## WEST SUSSEX COUNTY COUNCIL CONSULTATION

| <b>LOCATION:</b>           | The Grange, Westergate Street, Westergate, PO20 3SQ                                                                                                        |
| <b>SUBJECT:</b>            | AL/52/26/PL<br>Removal of mobile home and replacement with 1 No. self-build dwelling and associated works. This application is in CIL Zone 1 (Zero Rated). |
| <b>RECOMMENDATION:</b>     | Advice                                                                                                                                                     |

PROPOSED SITE AND ROOF PLAN

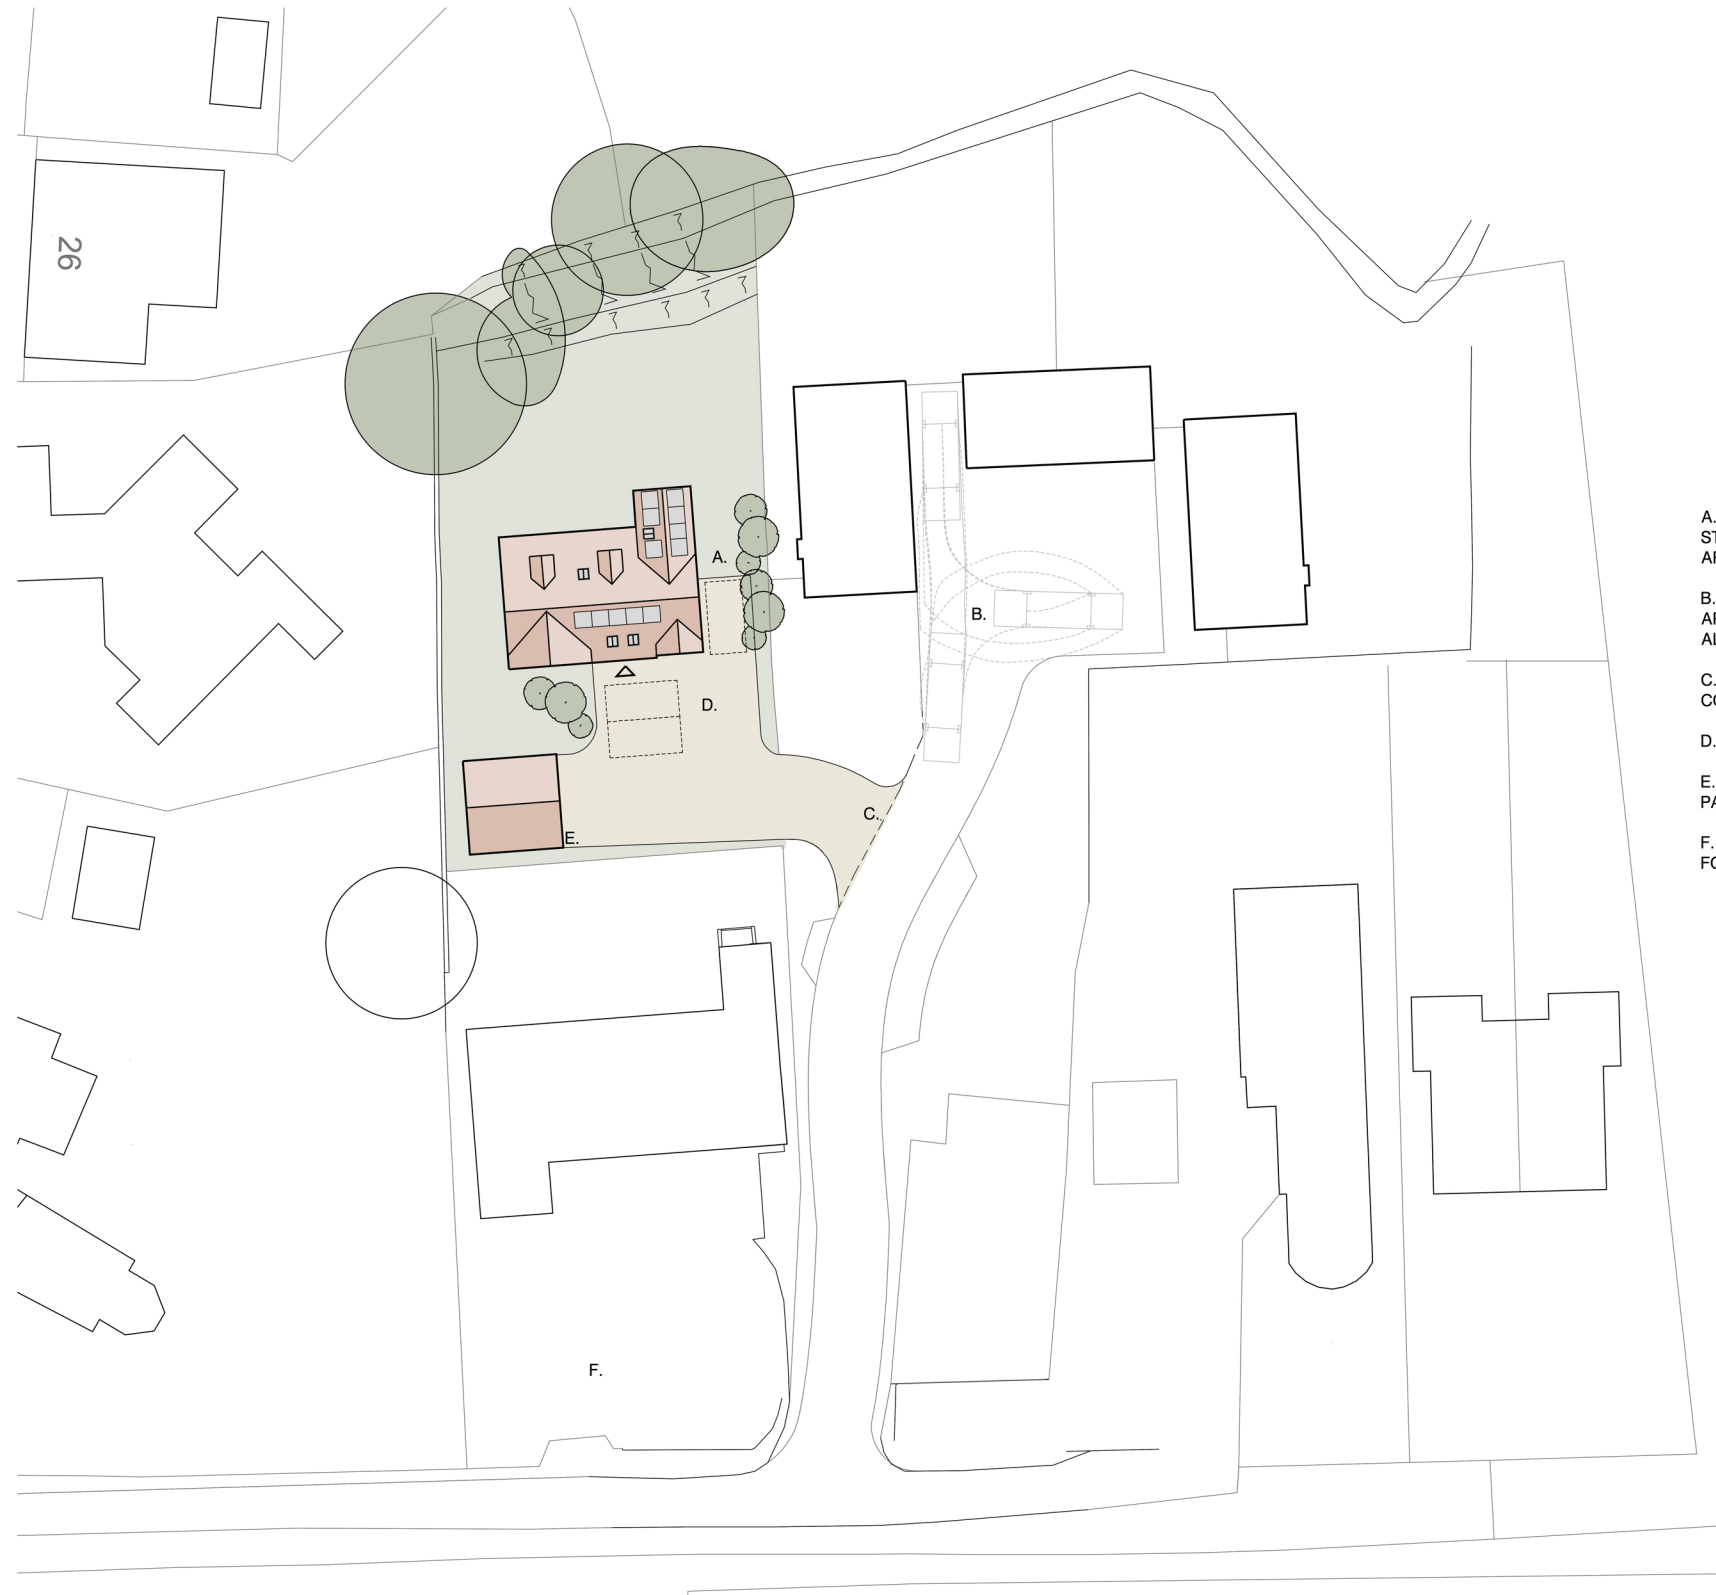
Regarding parking, a driveway with space for at least three cars is proposed, along with a detached double-bay garage. The proposed parking provision would be in accordance with Arun Parking Standards for a dwelling of this size and location. On-site turning appears achievable, allowing cars to exit the site in a forward gear. Swept path tracking has also demonstrated that a refuse vehicle/fire appliance can service the site and exit in a forward gear.

No part of the development shall be first occupied until the car parking has been constructed in accordance with the approved site plan. These spaces shall thereafter be retained at all times for their designated purpose.
